I would like to make my objection to PATHWAYS CREMORNE SENIORS HOUSING (SSD-49472213) known for the following reasons:

Owner/Resident of 92 Parraween St, Cremorne

2 3pm 22 June Proposed

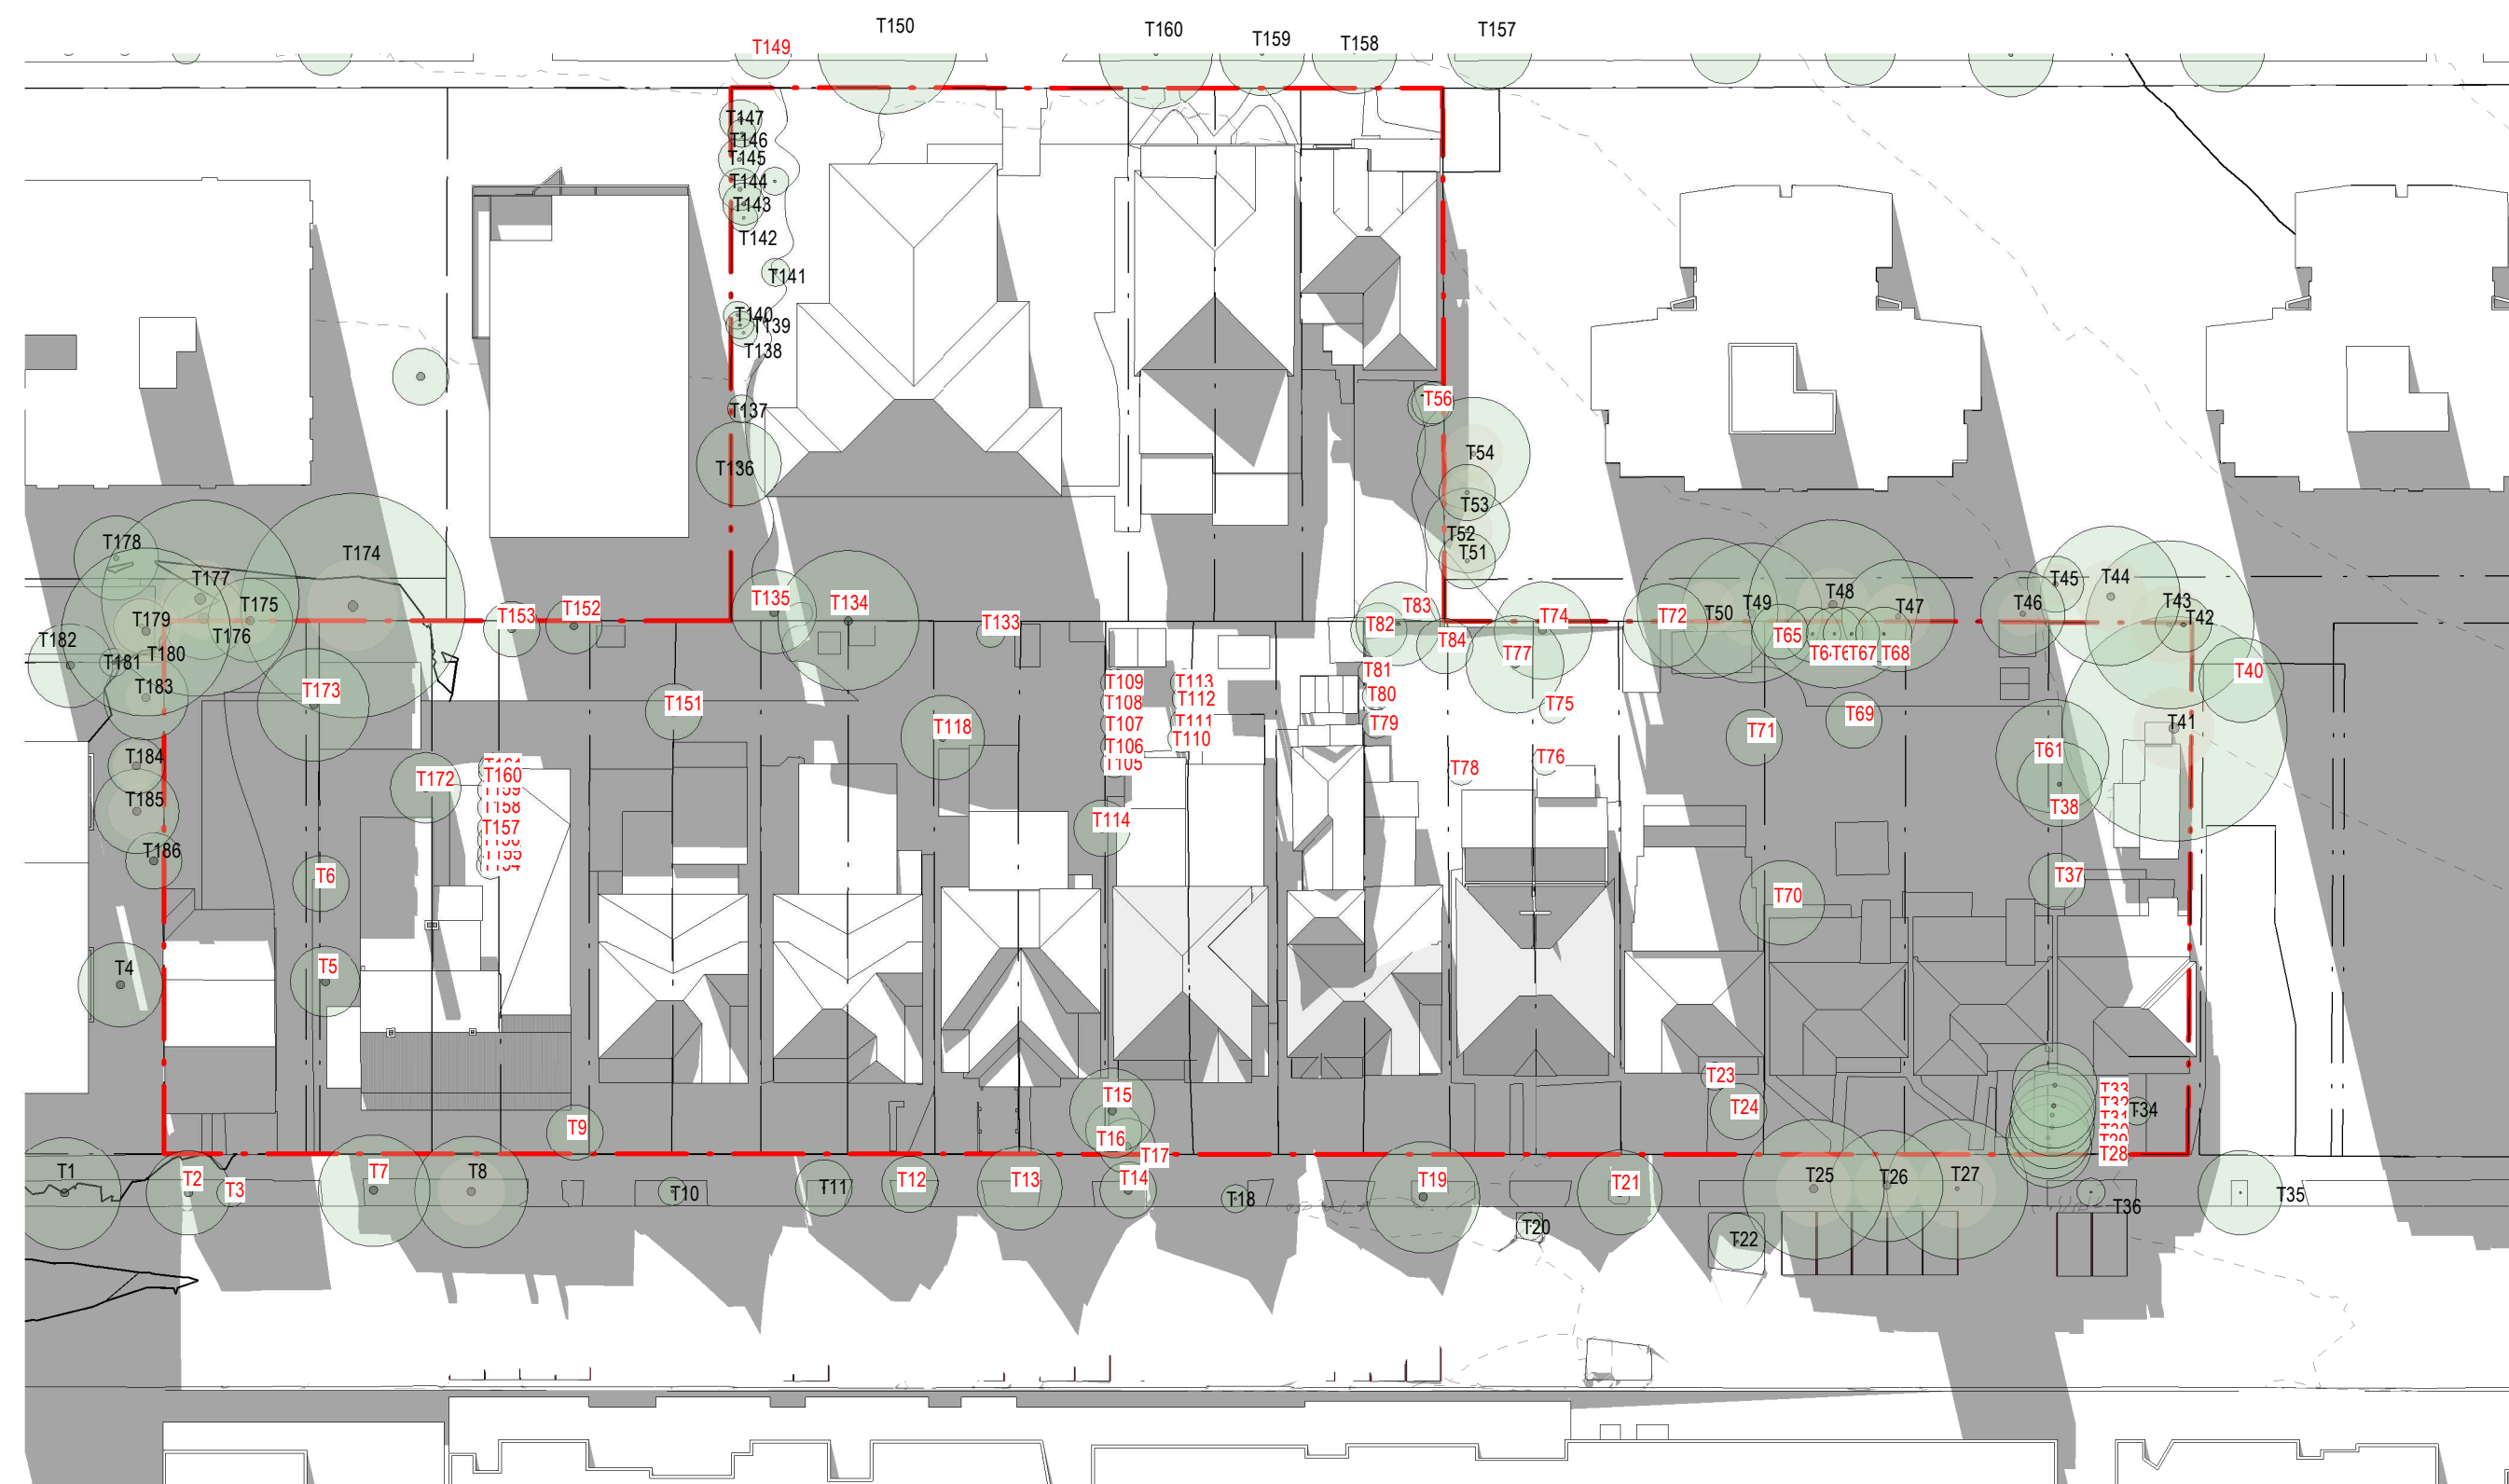
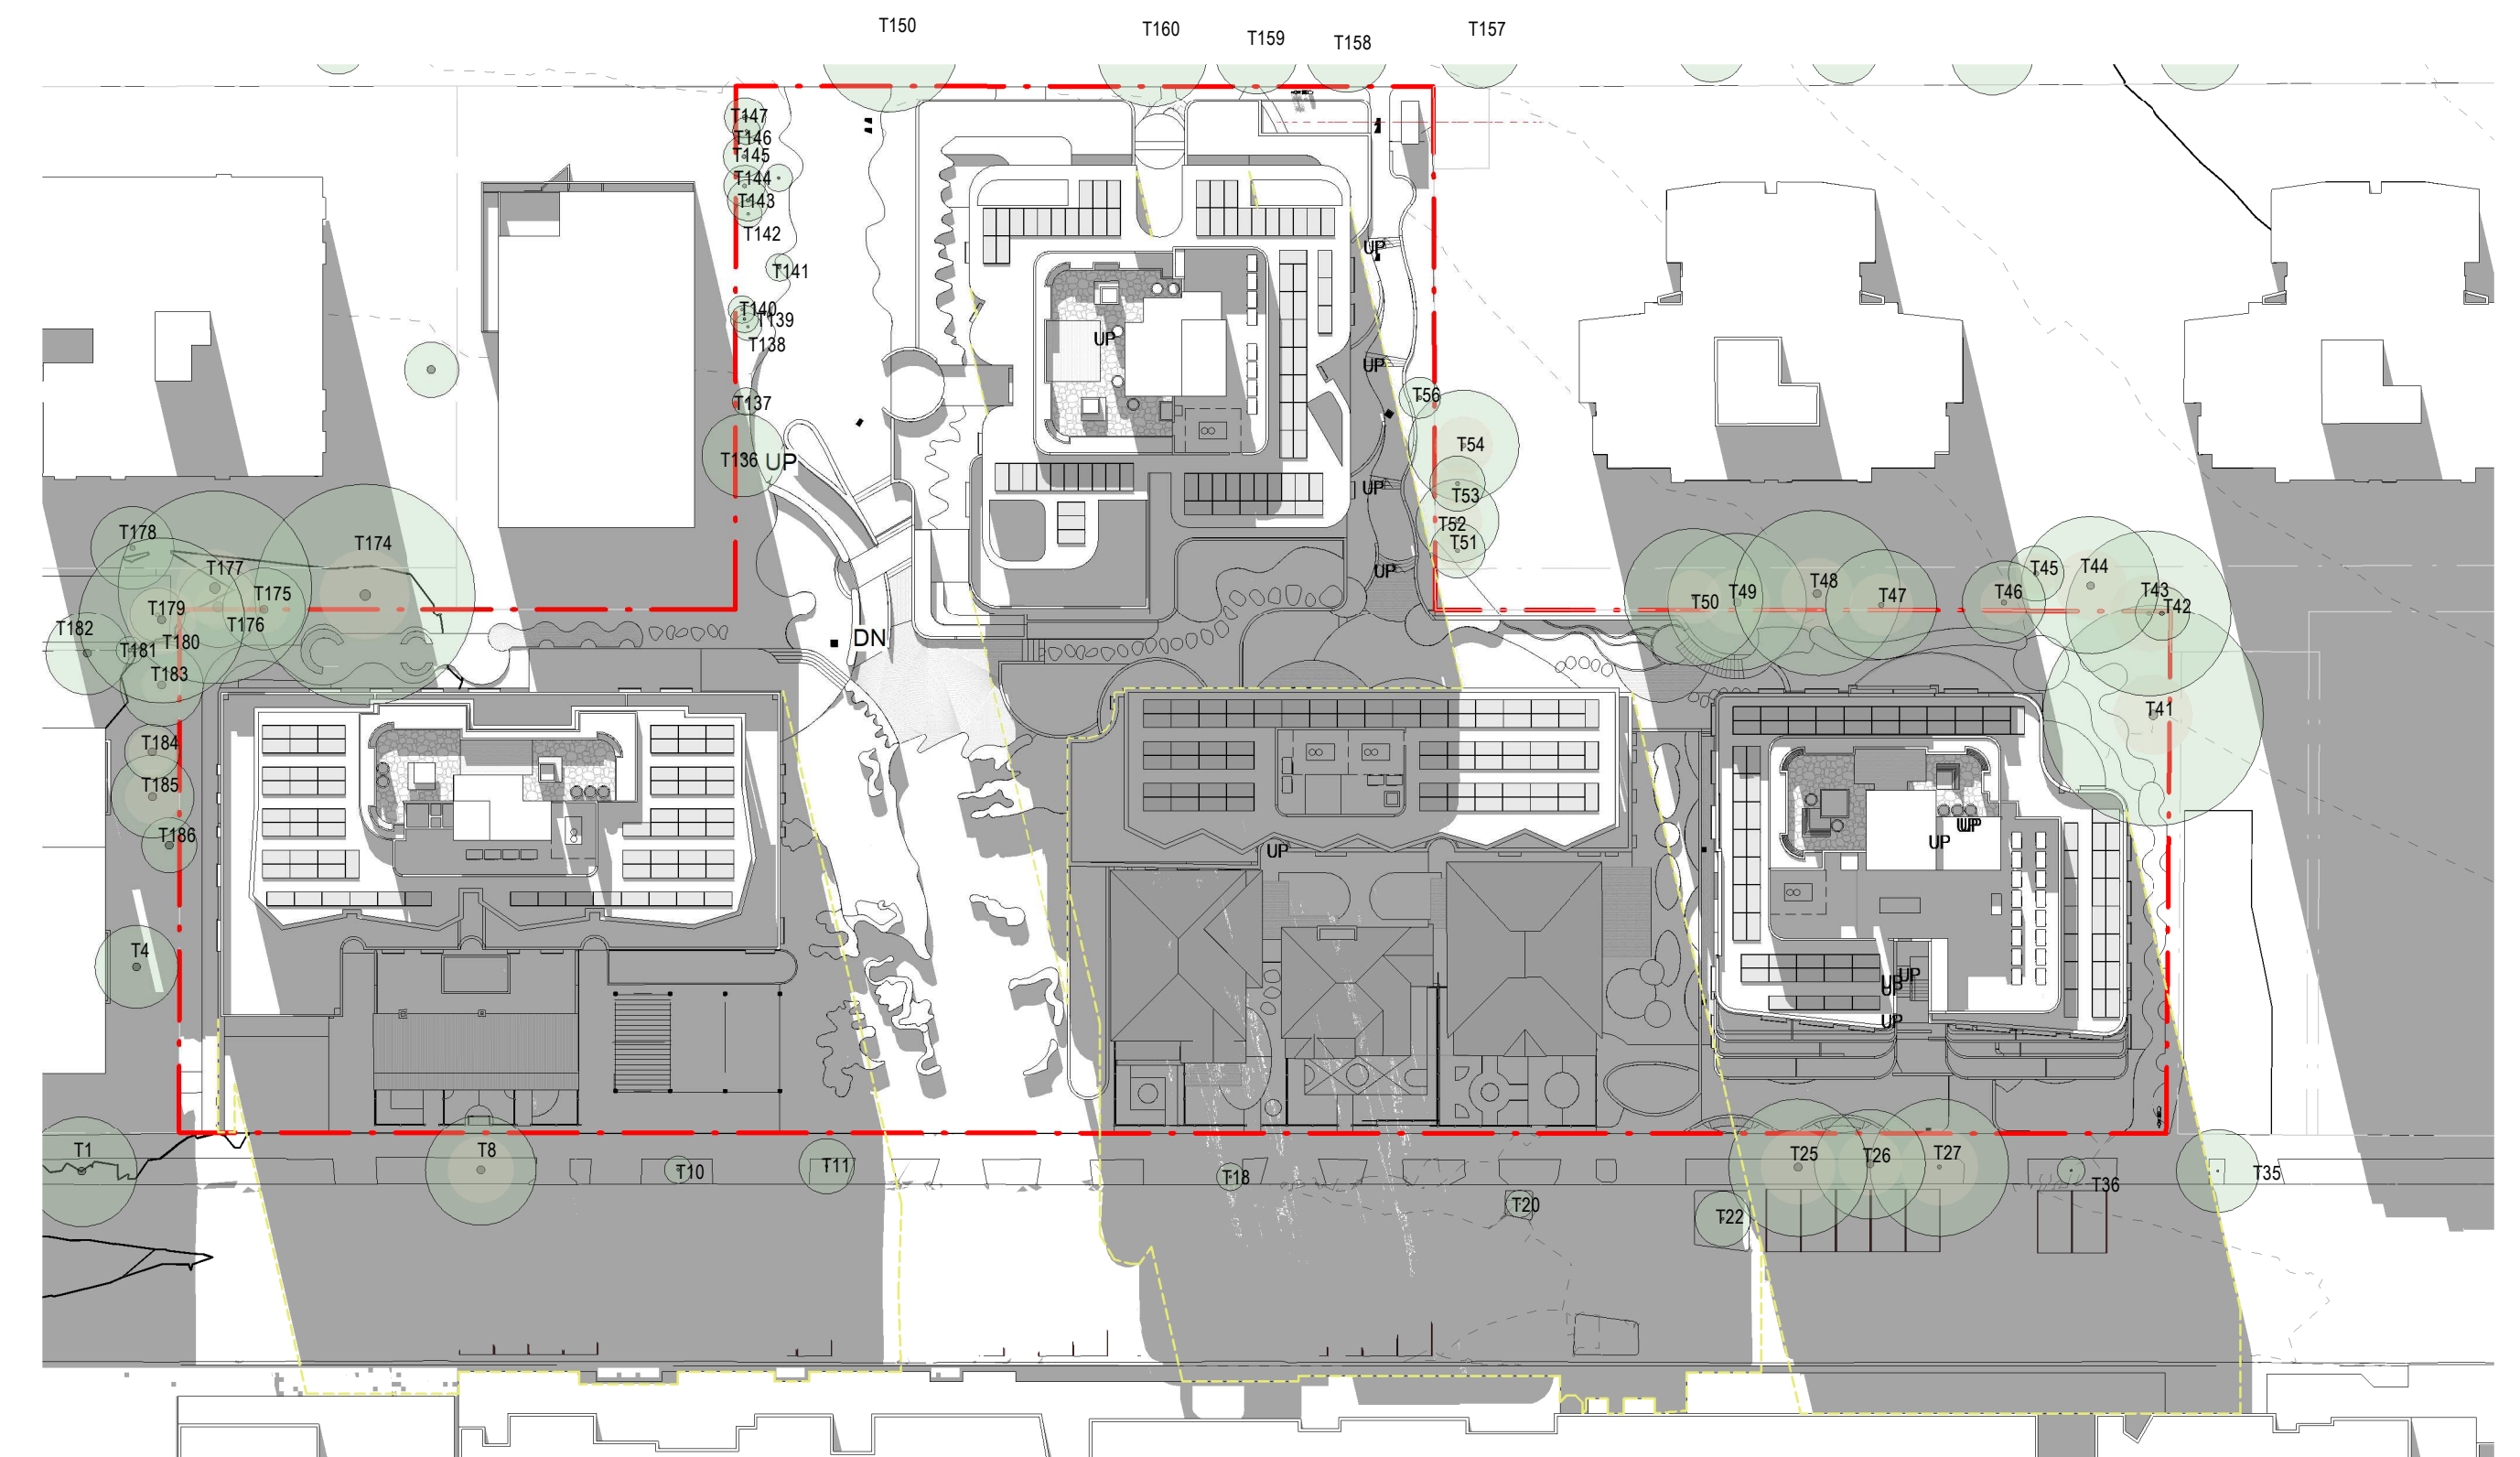
- 6.3.1.4 OVERSHADOWING

The amended application states “The property to the east is not impacted by shadows at all.” This is incorrect, the building to the east is 92 Parraween Street a 3-4 storey building. The units on the western side only get sun for 2 hours in the afternoon during winter. I know as I have lived there for 4 years. As per the amended project the building has a maximum building height of 4 storeys (15.274m). This could mean that these units would effectively get no sun during the winter. I note that the previous report as well as the amended report do not make mention of the unit blocks that are directly neighbouring it to its eastern, southern and northern aspects. It also does not have later afternoon in any of their shadowing projections. I also note none of the drawings show 92 Parraween Street in relation to the eastern edge of the development/building 1. One could infer that 92 Parraween Street was not included on diagrams/schematics to **minimise the perceived impact on the adjacent buildings.**
